**Subject: Plaza Trim Road Development – 1280 Trim Rd, Ottawa, ON  
Response to Engineering Comments**

Dear Ms. Ramirez,  
Please find attached a copy of the following documents re-issued for approval for the proposed development mentioned above. These documents have been re-issued in response to the review comments dated July 23, 2024.

C301

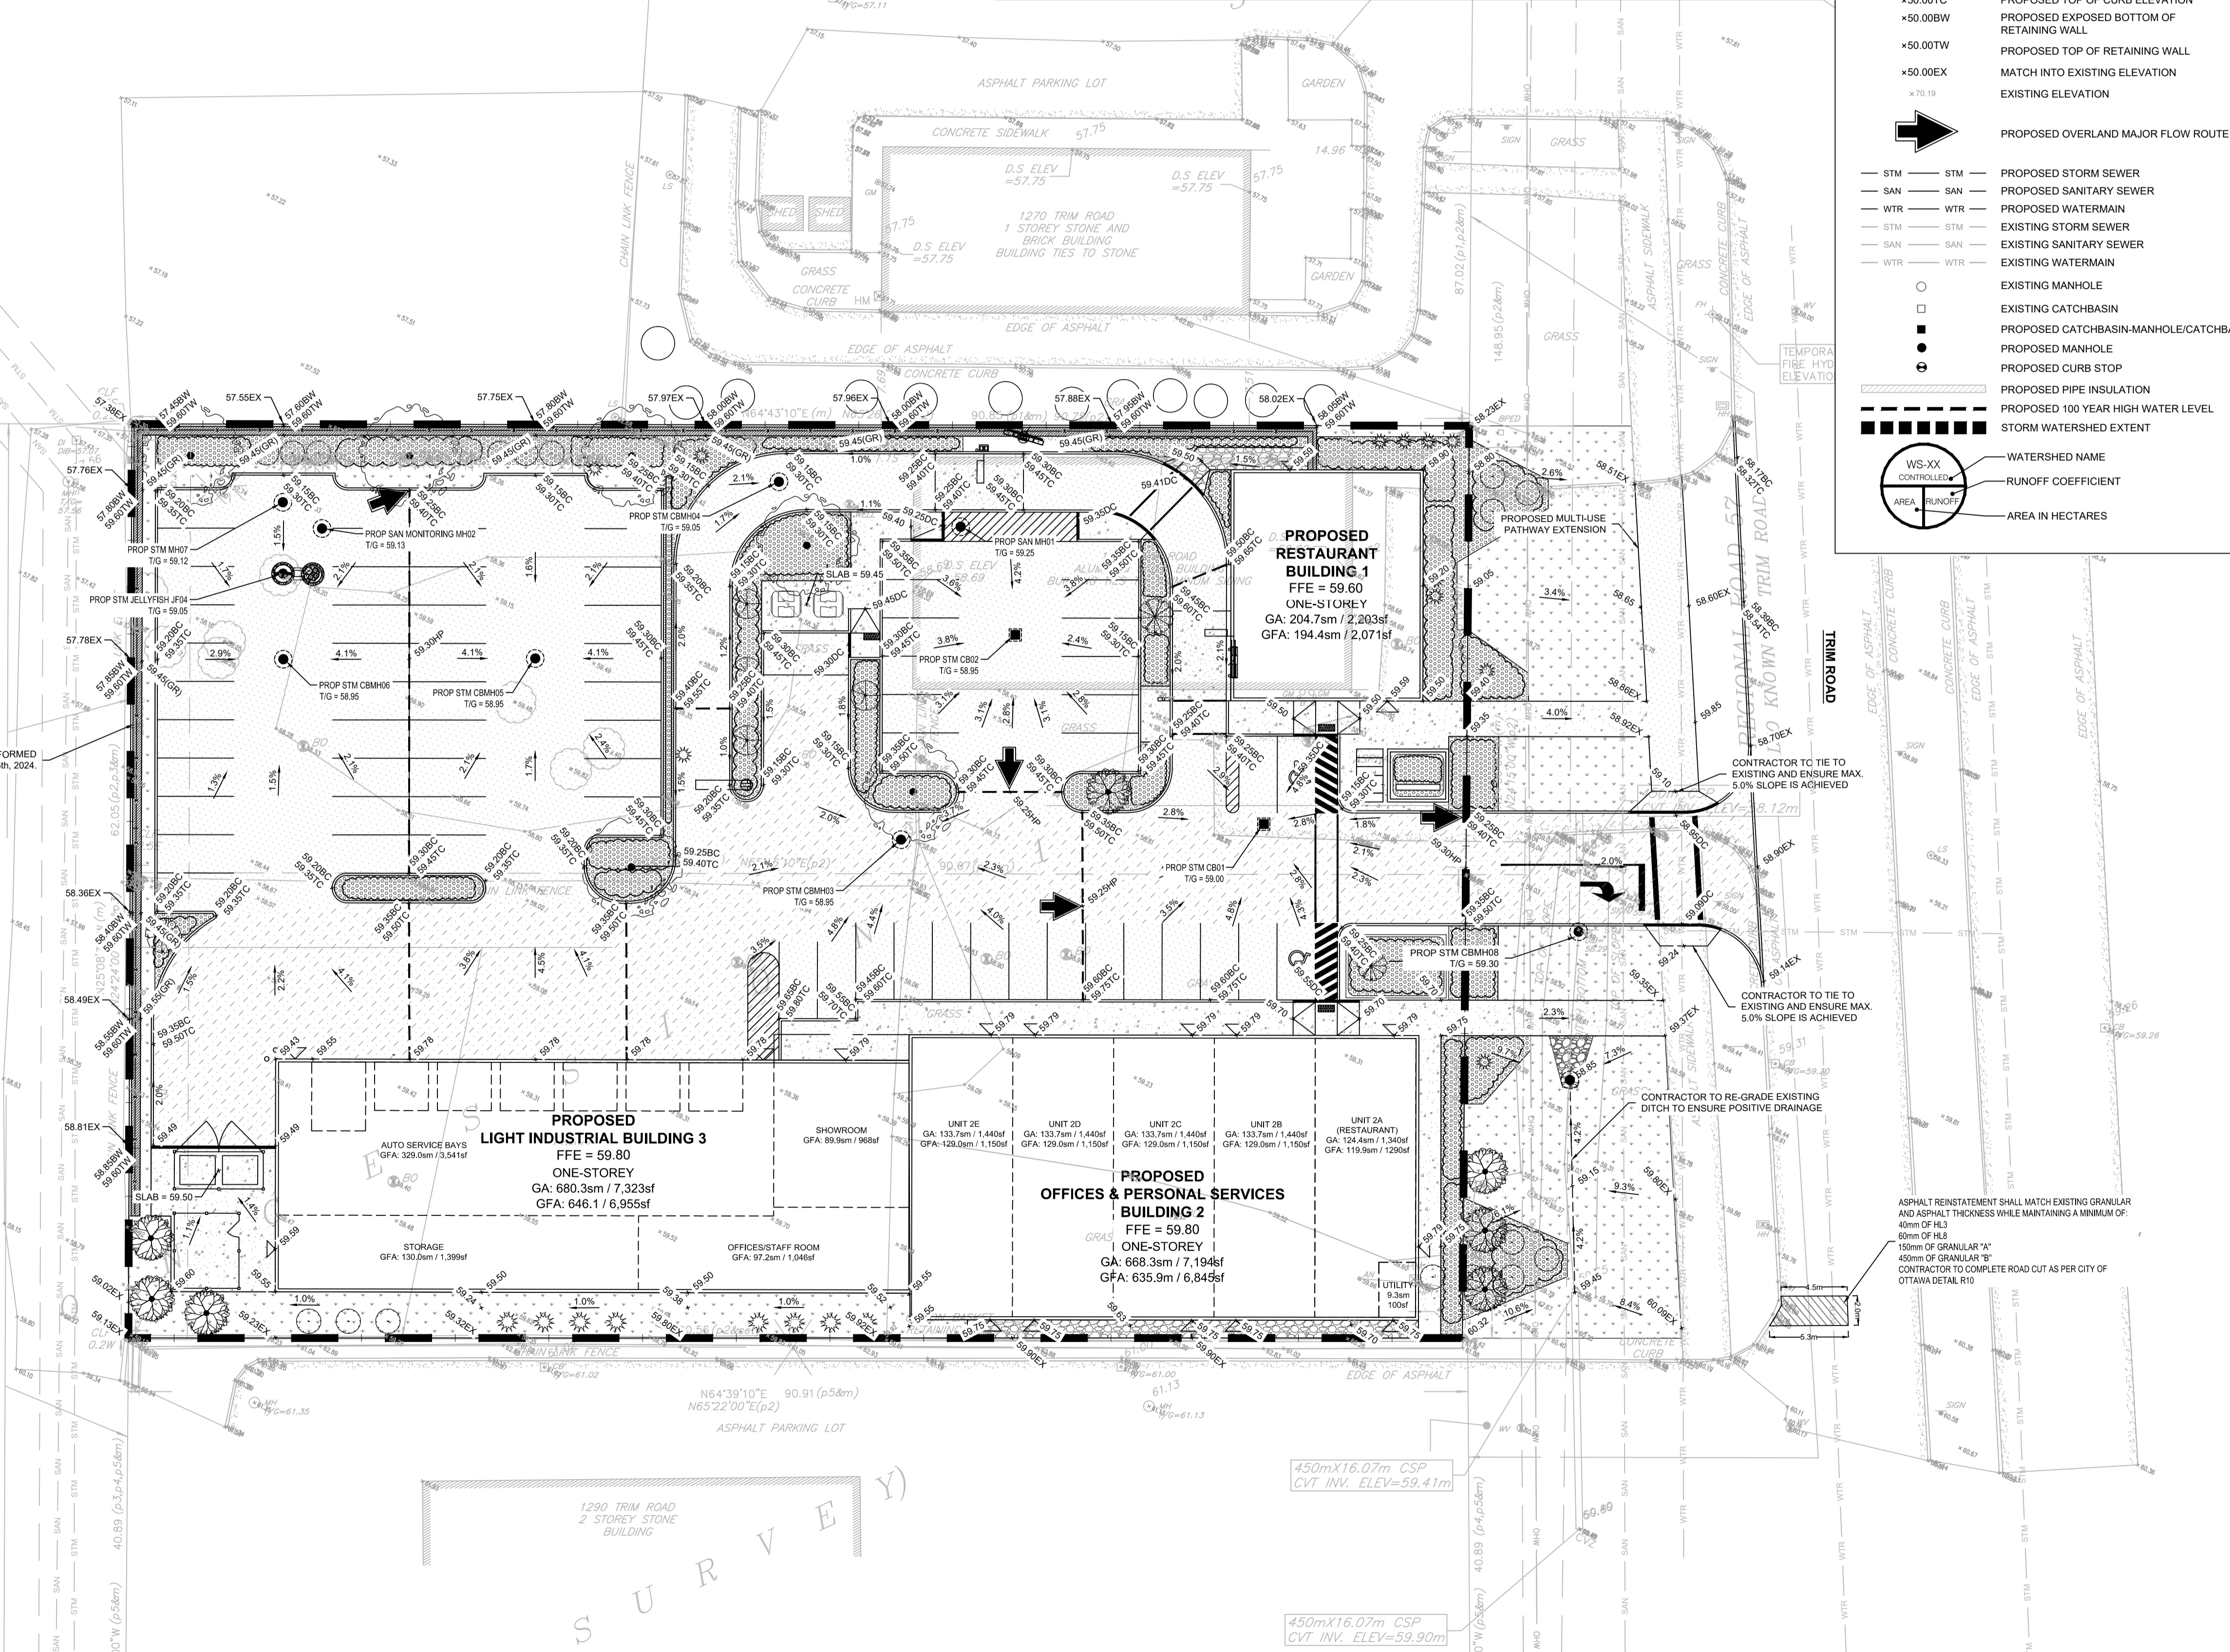
<b>City's Comment</b>	The proposal of filling in the ditch has not been demonstrated as feasible. The report shall demonstrate that upstream flows can be accommodated and that the condition of the existing 200mm CB lead is acceptable for re-use.
<b>LRL Response</b>	Based on the latest correspondence with City, the comment above has been resolved and SWM report revised accordingly, please see Section 5.5 (last paragraph) of the report. Based on CCTV, the condition of existing CB lead appears acceptable.
